# CITY OF ALBUQUERQUE

**RE: 2500 Louisiana NE  
Grading and Drainage Plan  
Engineer's Stamp Date: 6/17/24  
Hydrology File: H19D095**

Based upon the information provided in your submittal received 06/18/2024, the Grading & Drainage Plan **is not** approved for Building Permit and Grading Permit. The following comments need to be addressed for approval of the above referenced project:

sheet no: C-101

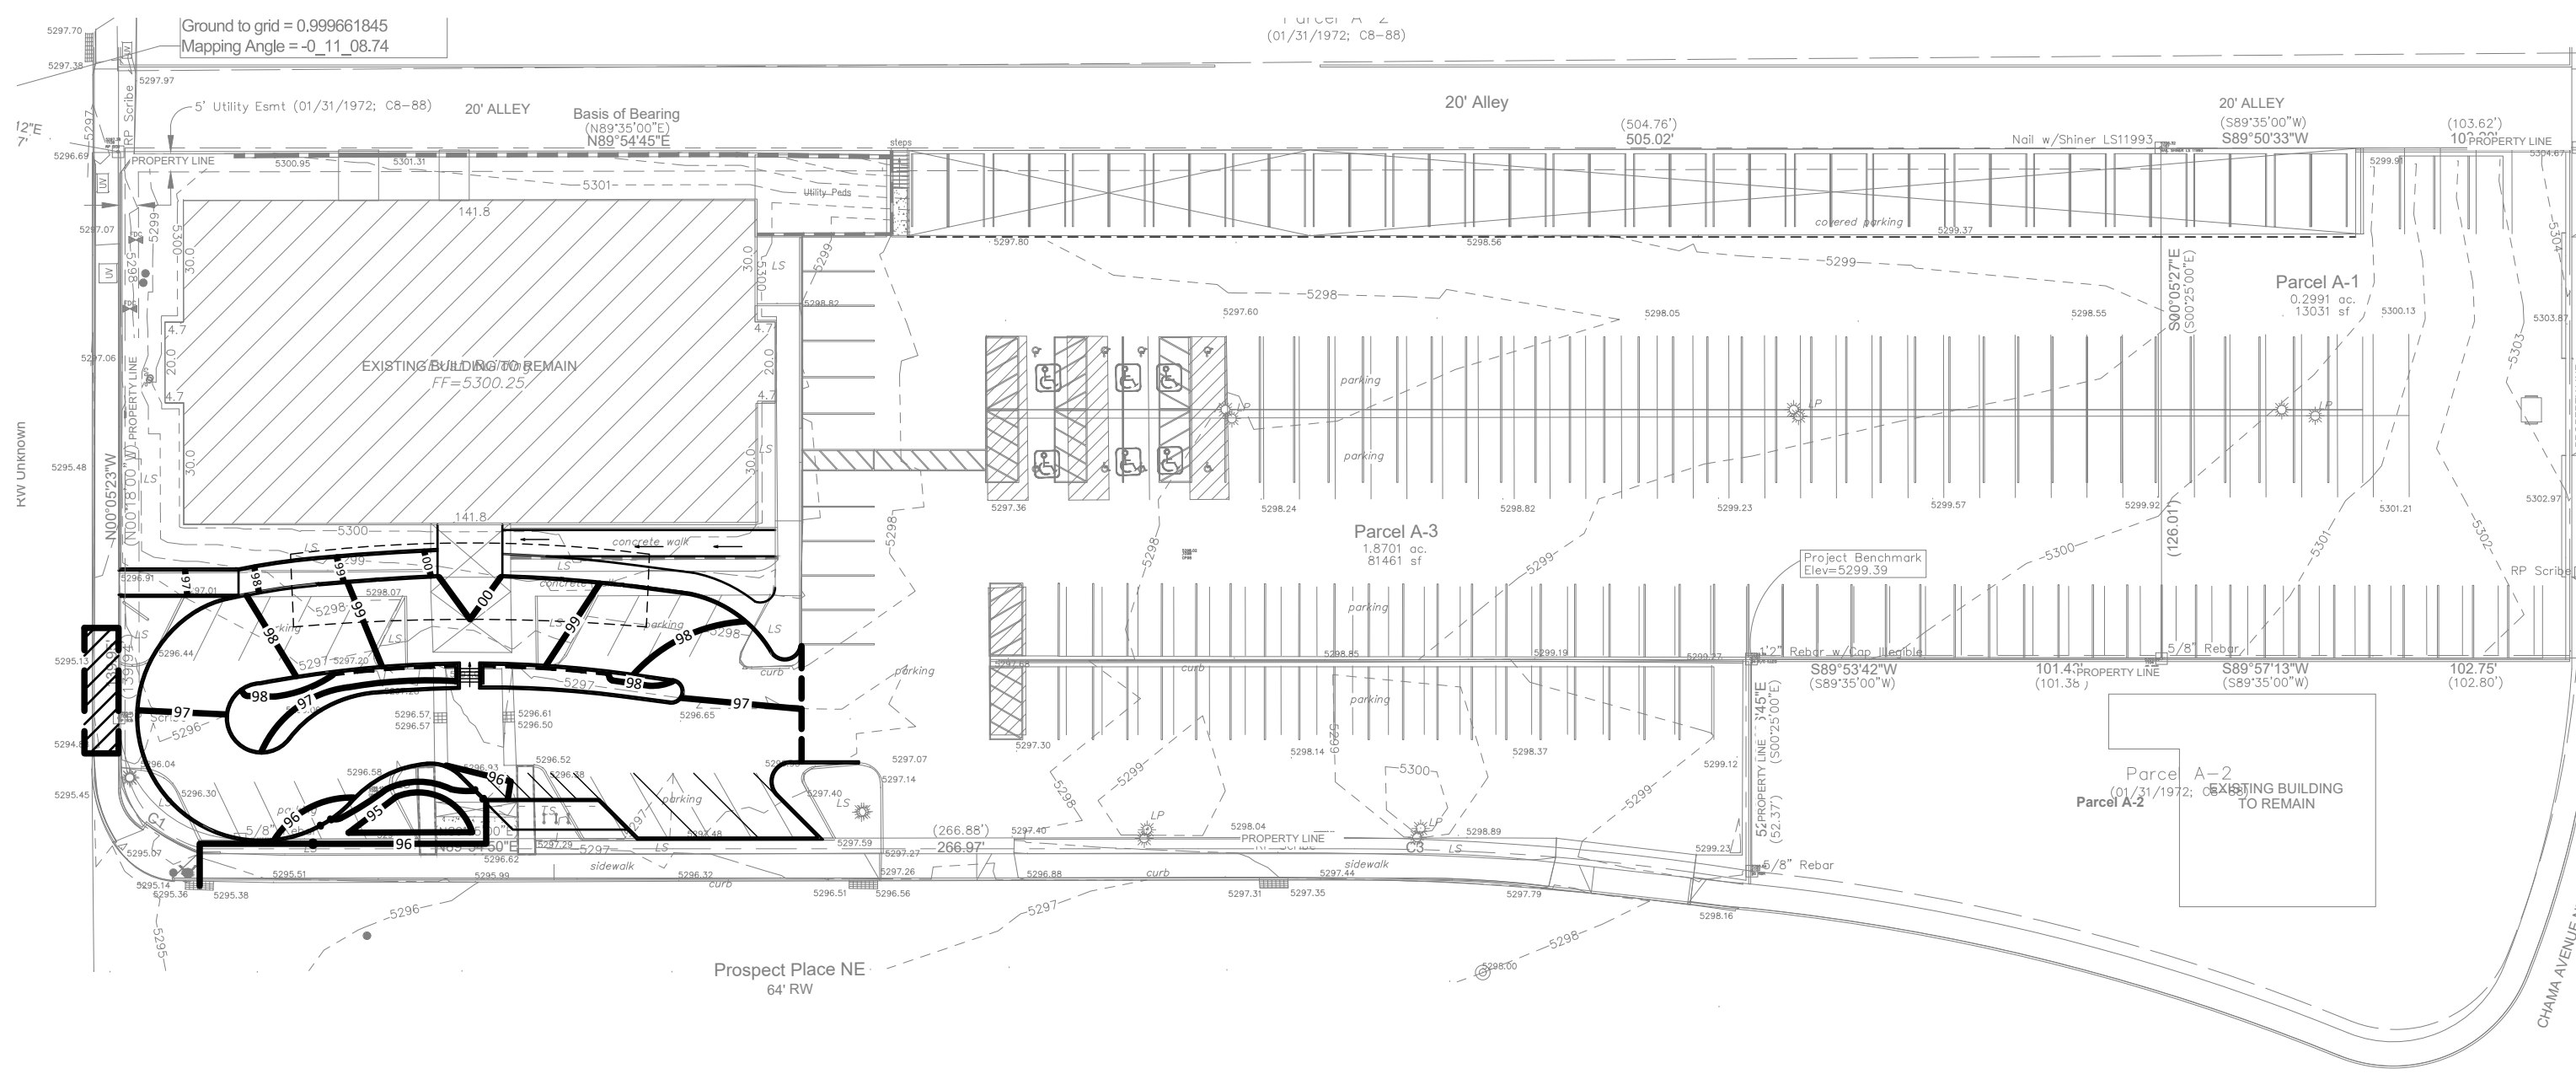
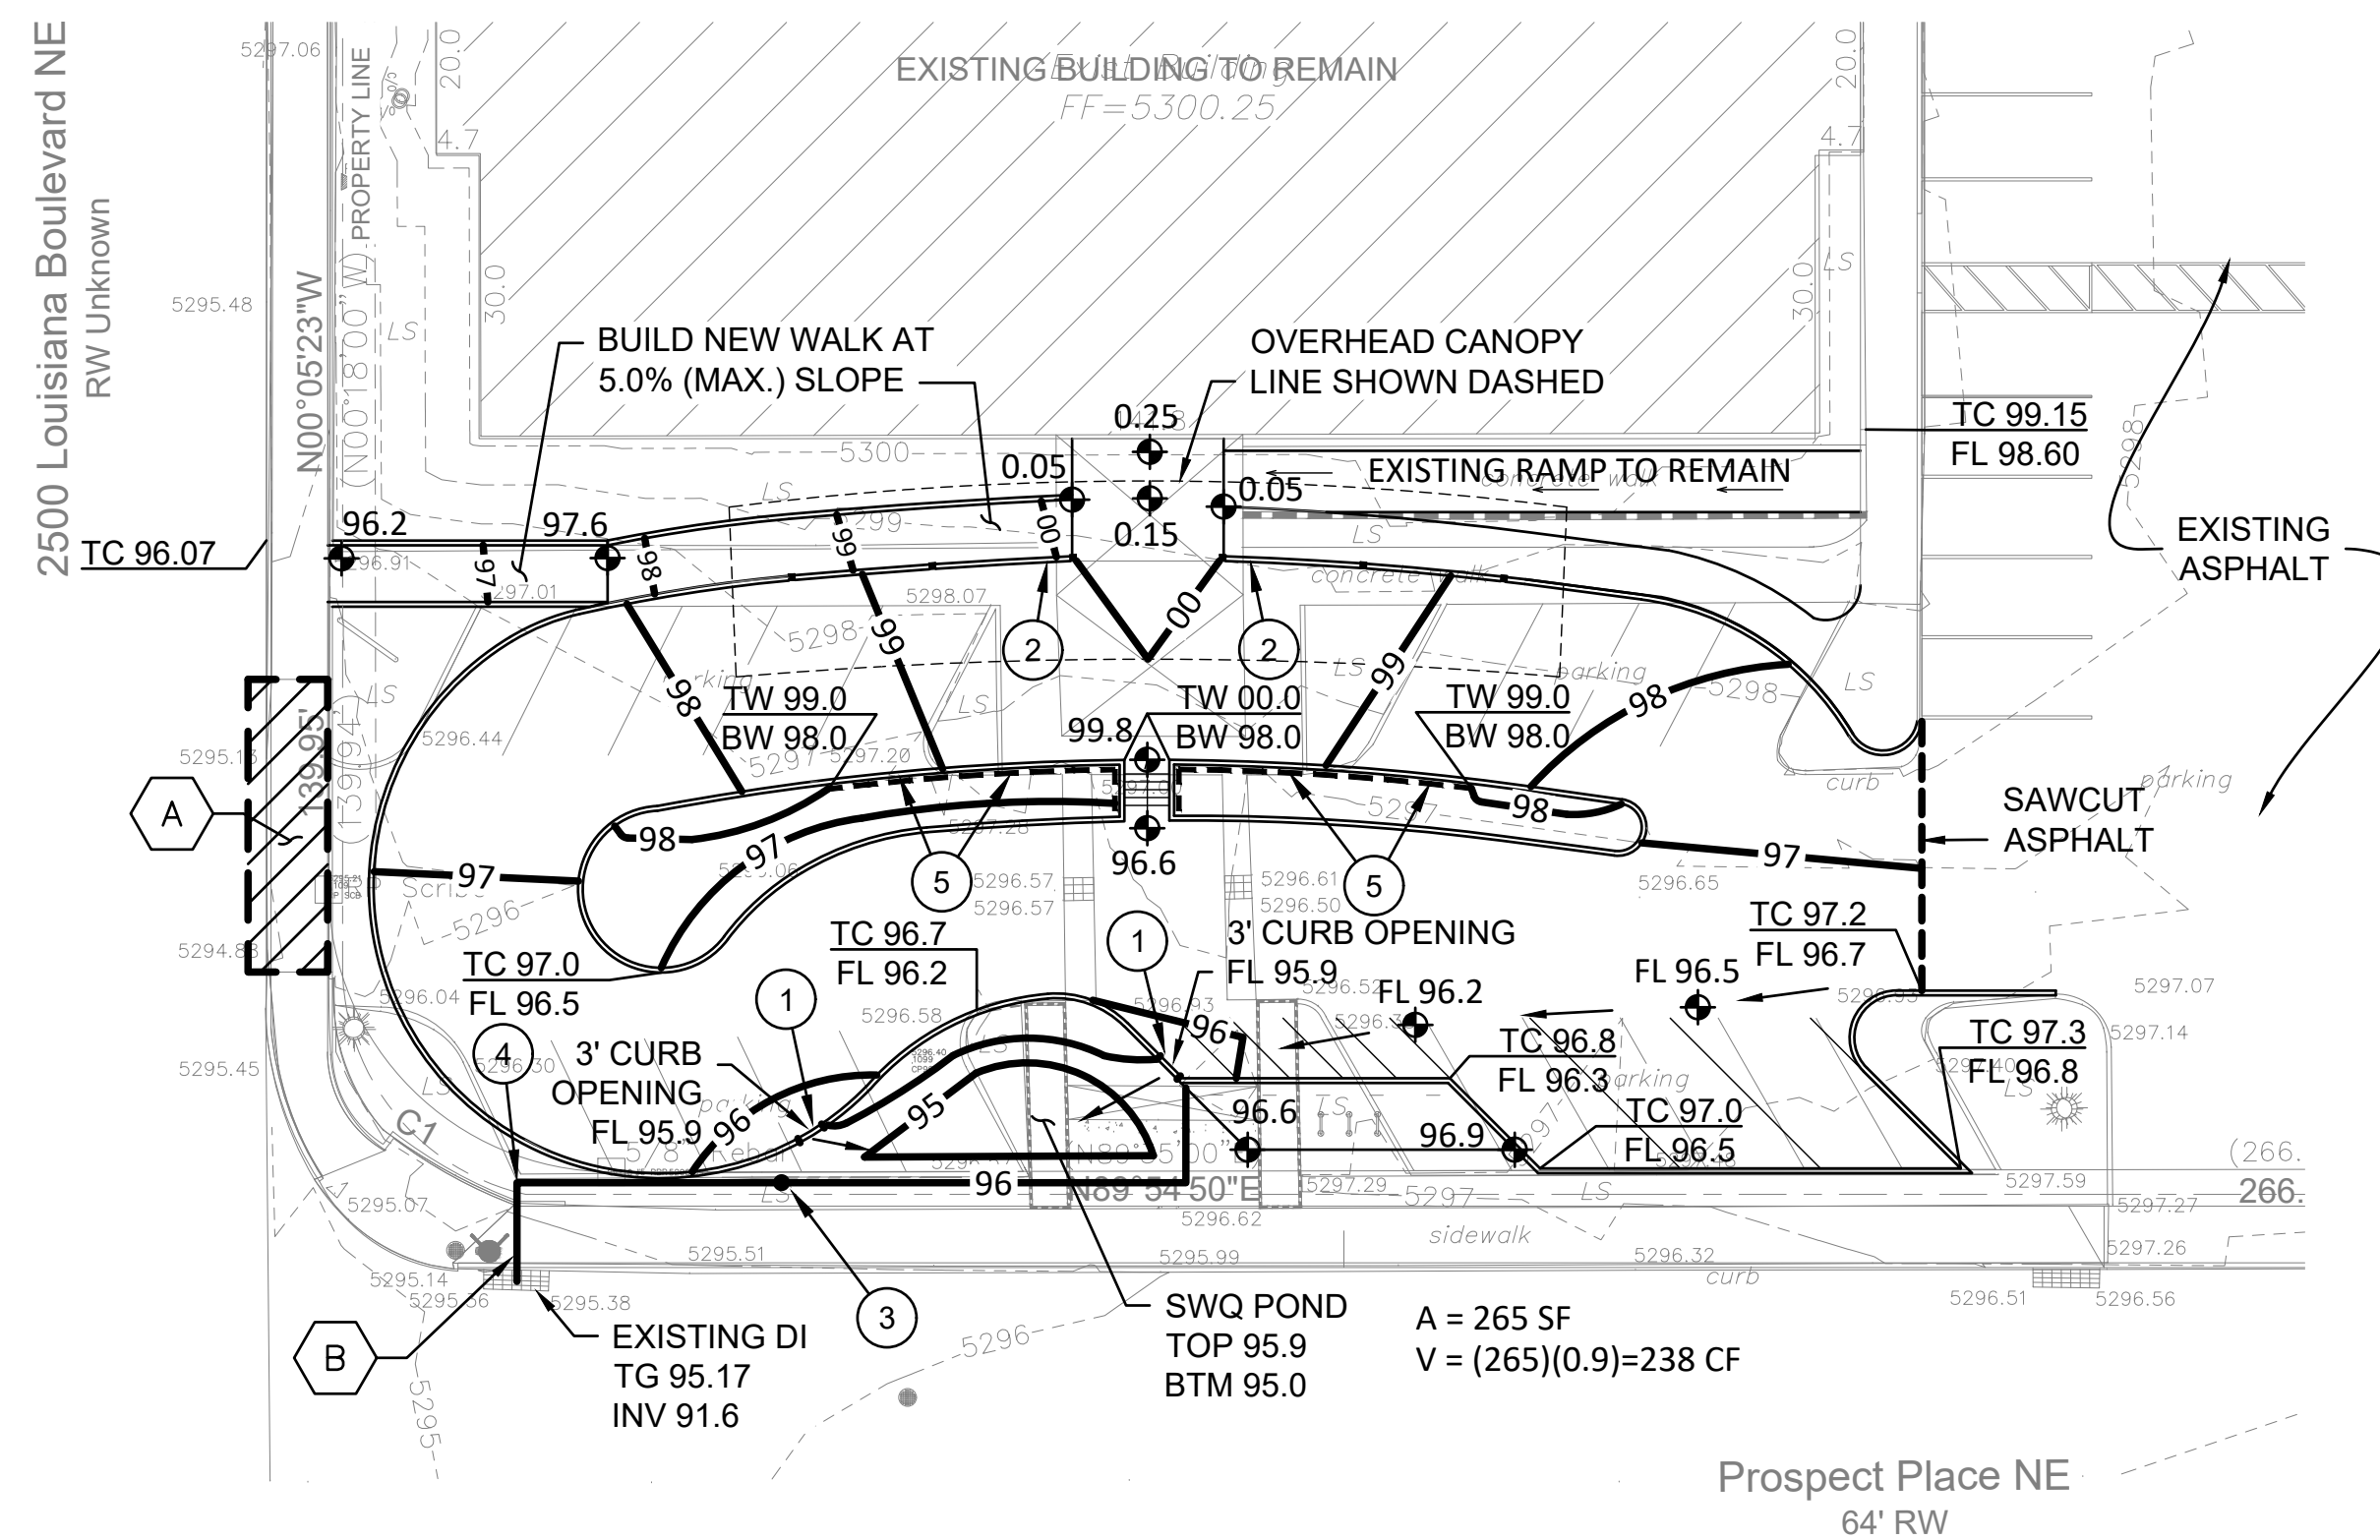
1. The calculation table and narrative sections appear to be cut off. Please show the missing information.
2. An SO-19 Permit will be required and should be included on the request.

3. Please include the standard SO-19 notes on the grading plan. Please check the notes and add any missing note(s) to the section.
4. Please provide the Benchmark information (location, description and elevation) for the survey contour information provided.

5. Please use 1" = 20' for the scale.
6. Please provide the correct FIRM Map and flood plain note with effective date. The map referenced does not seem to be for this site.

7. Please provide the SWQV calculations on the plan. Provide management onsite for the Stormwater Quality Volume (SWQV) in accordance with the new drainage ordinance, § 14-5-2-6 (H). Please follow the DPM Article 6-12 Stormwater Quality and Low-Impact Development for the sizing calculations. To calculate the required SWQV, multiply the impervious area draining to the BMP by 0.26 inches for redevelopment sites. The calculations of both the required and the provided volume of each BMP must be shown on the Grading and Drainage Plan.

8. Payment in Lieu (Amount = 210CF x \$8/CF = \$1680, per sheet C-1) of onsite management of the SWQV must be made. Take three copies of the treasury deposit slip to the Treasury and then include one copy of the paid deposit slip when resubmitting.

9. Please show the Payment in Lieu calculation on the plan.
10. Please add a note which states, "The Owner has elected to pay the Payment in Lieu for the required Stormwater Quality Volume."
